**RE: 606 and 616 Forest Avenue. Walgreens Pharmacy
Application # 2007-0188**

RE: Review Comments for Revised Photometric Plan – Administrative Review

Project Name: Forest Avenue - 606 & 616; Walgreens Pharmacy; The Richard Company
Project ID: 09-99600007
Project Address: 606 Forest Ave CBL: 125 - L-006-001
616 Forest Ave CBL: 125 - L-007-001

C1.1

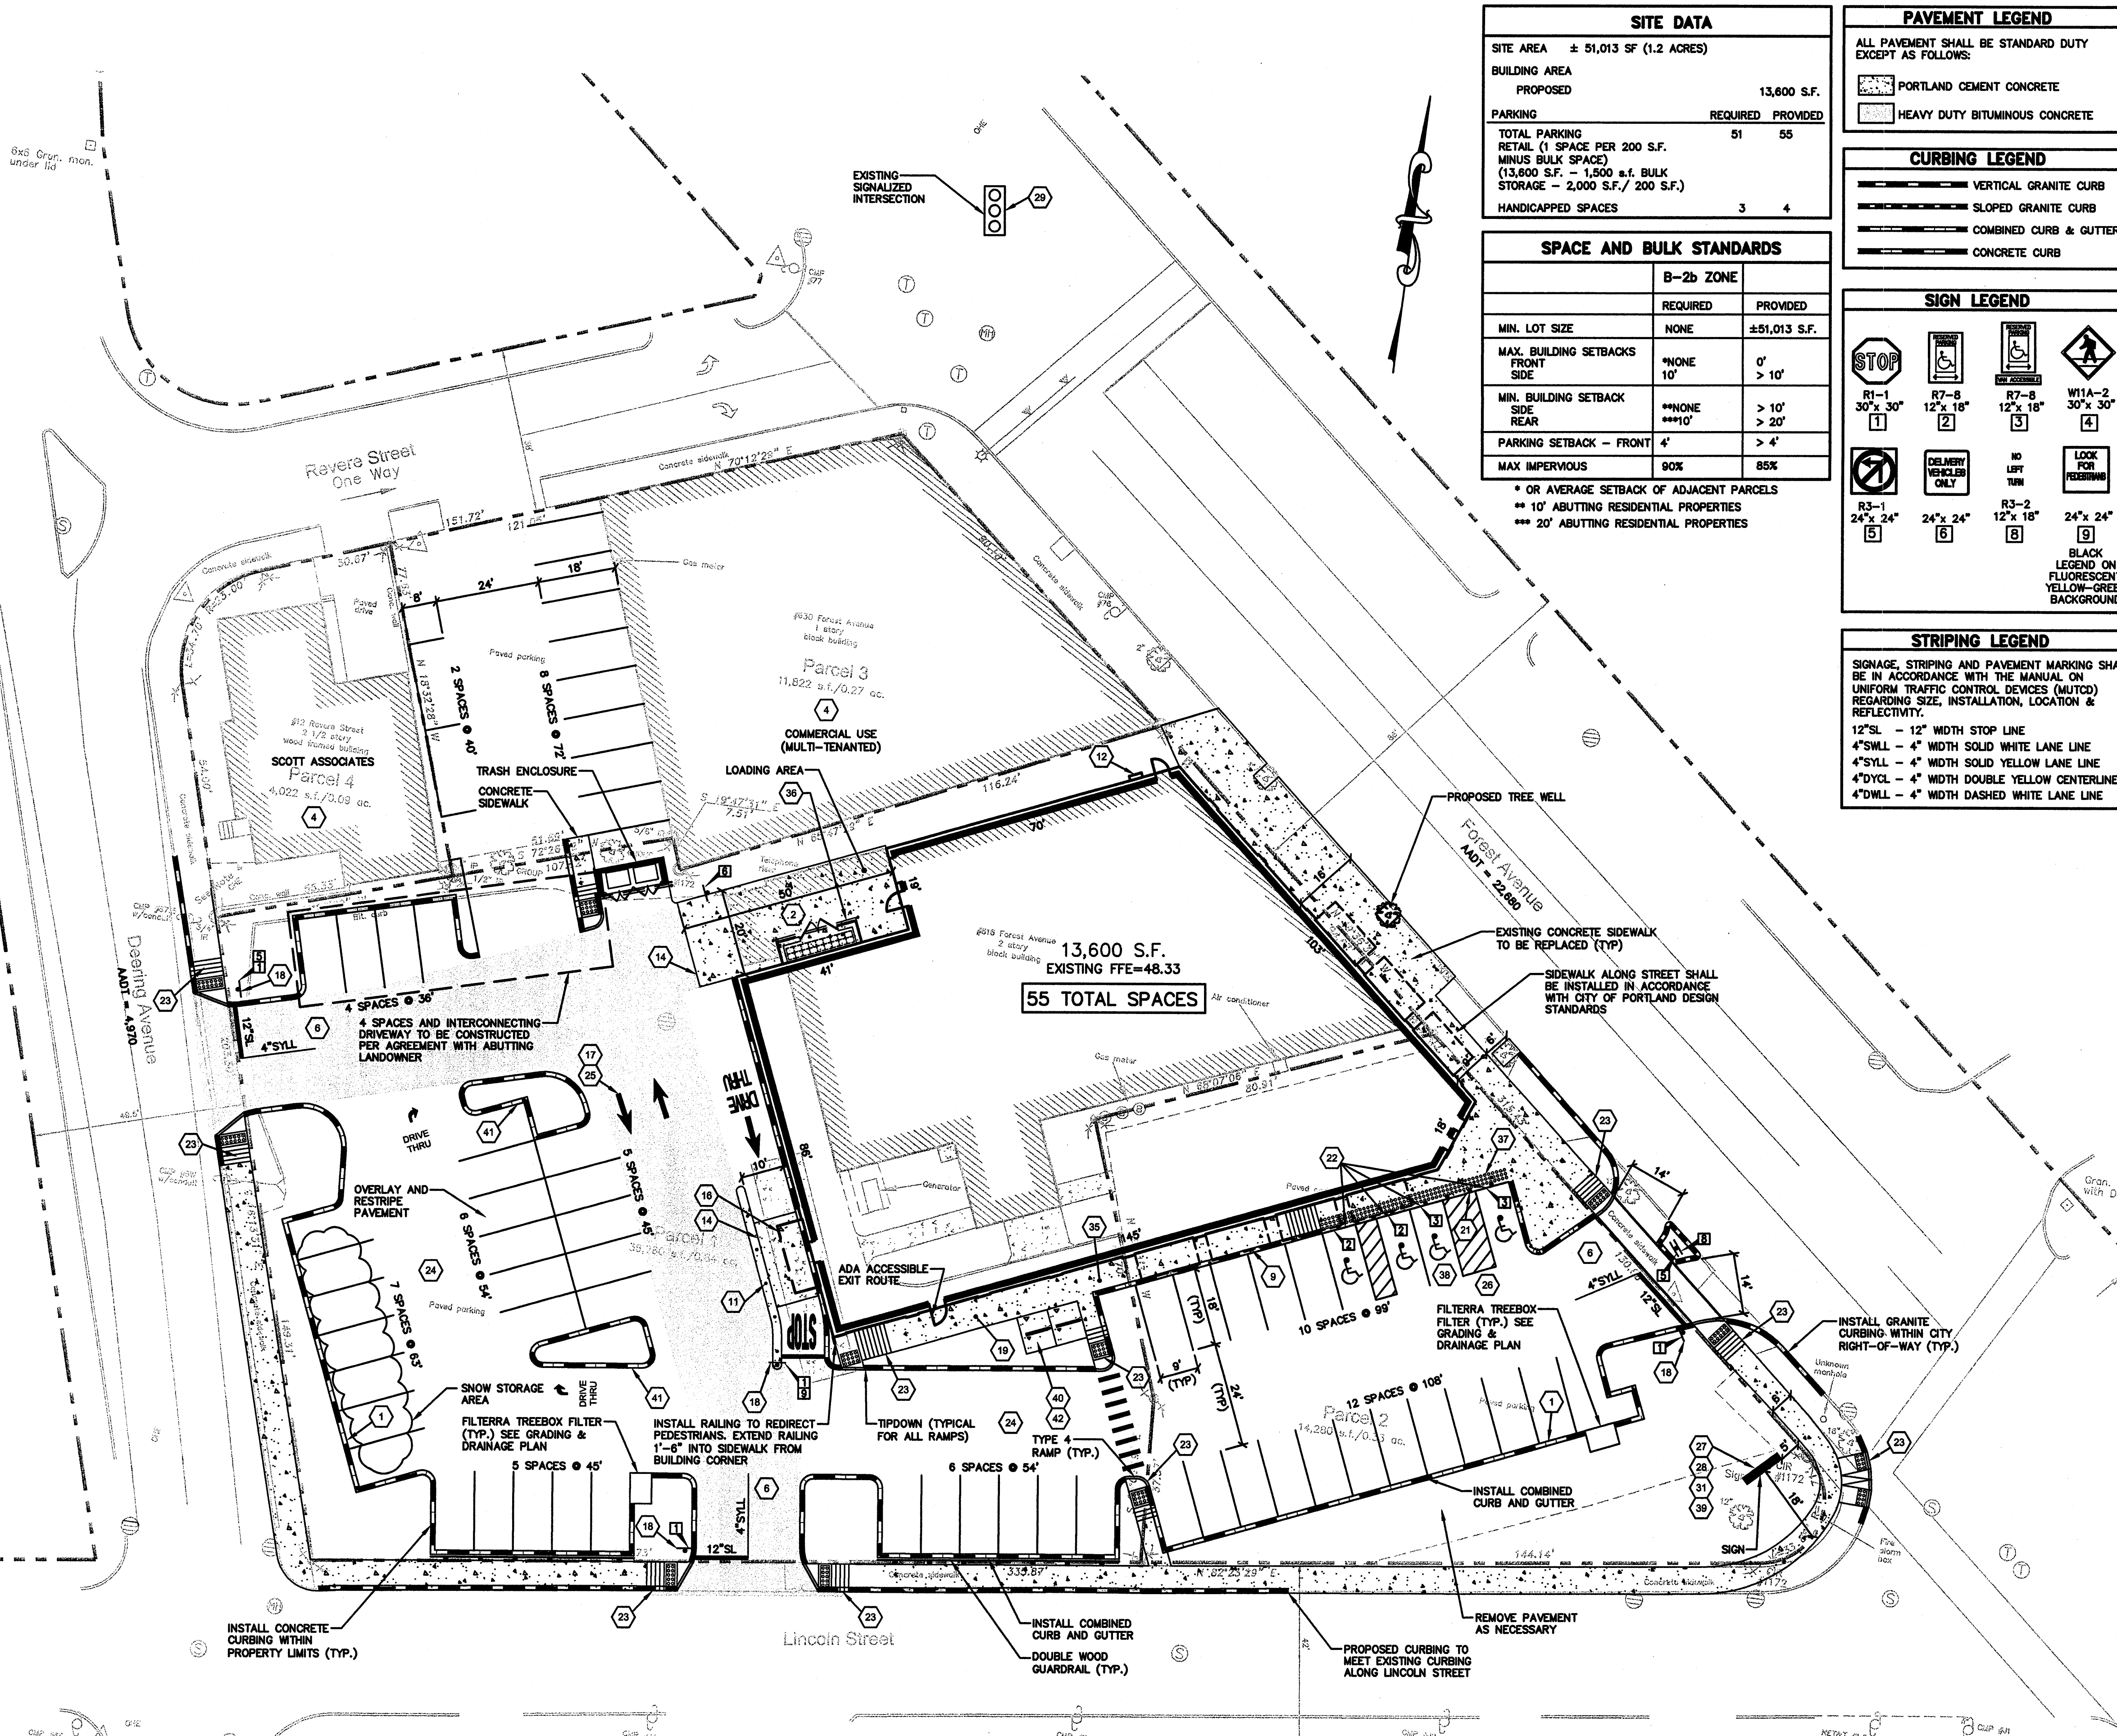
Thank you for submitting a proposed amendment to the approved site plan for Walgreens Pharmacy at 606-616 Forest Avenue. It is our understanding that the proposed changes, as shown on the submitted site plan dated September 16, 2009 and labeled sheet C1.1, include extending the proposed tote storage area an additional ten feet to allow for covered storage of cardboard recycling. The depth of the tote storage area will remain as originally approved at 5 ft 4 inches. Please submit one final copy of the revised final site plan to the Planning Division for our records.

The proposed changes represent a de minimis amendment to the approved site plan and have been reviewed and approved by the Planning Authority.

Drawing file: PDF 081576 / L1_Landscape & Irrigation Plan.pdf

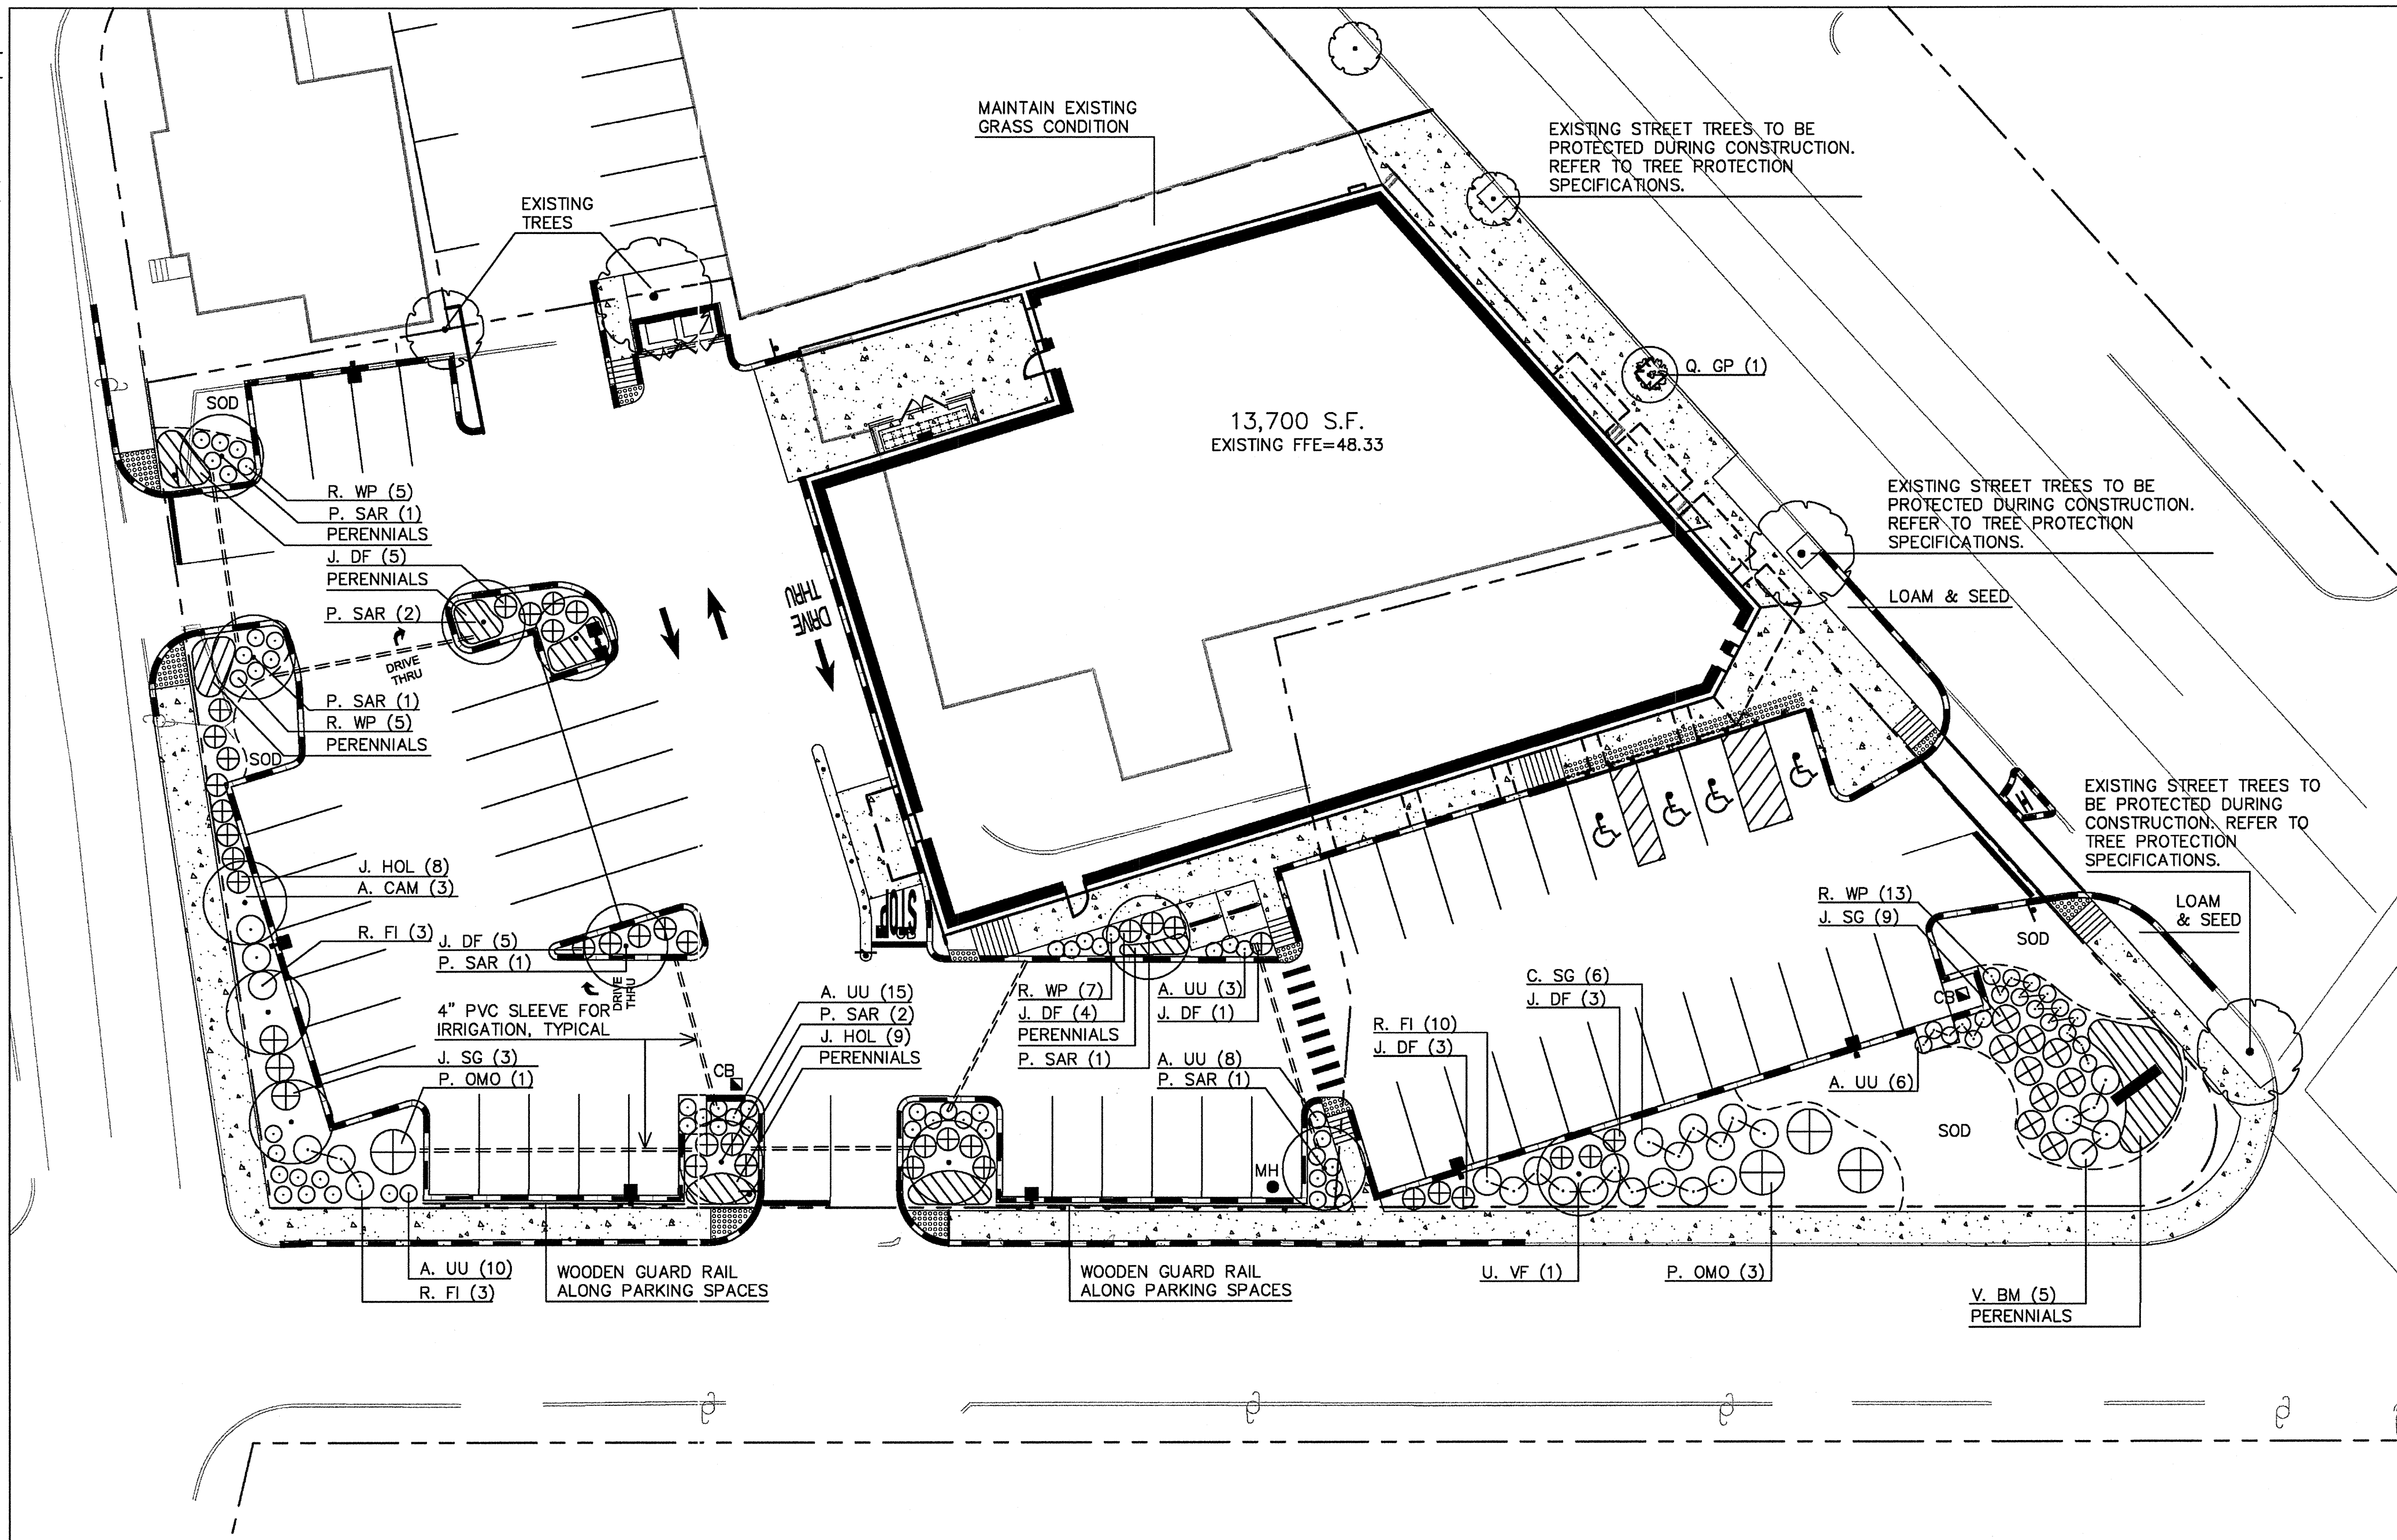
8. Double wooden guardrails shall be added to the two areas on either side of the Lincoln Street driveway to provide adequate edge treatment. A revised landscape plan that includes these guardrails shall be submitted for review and approval by the City Arborist prior to the issuance of a Building Permit.
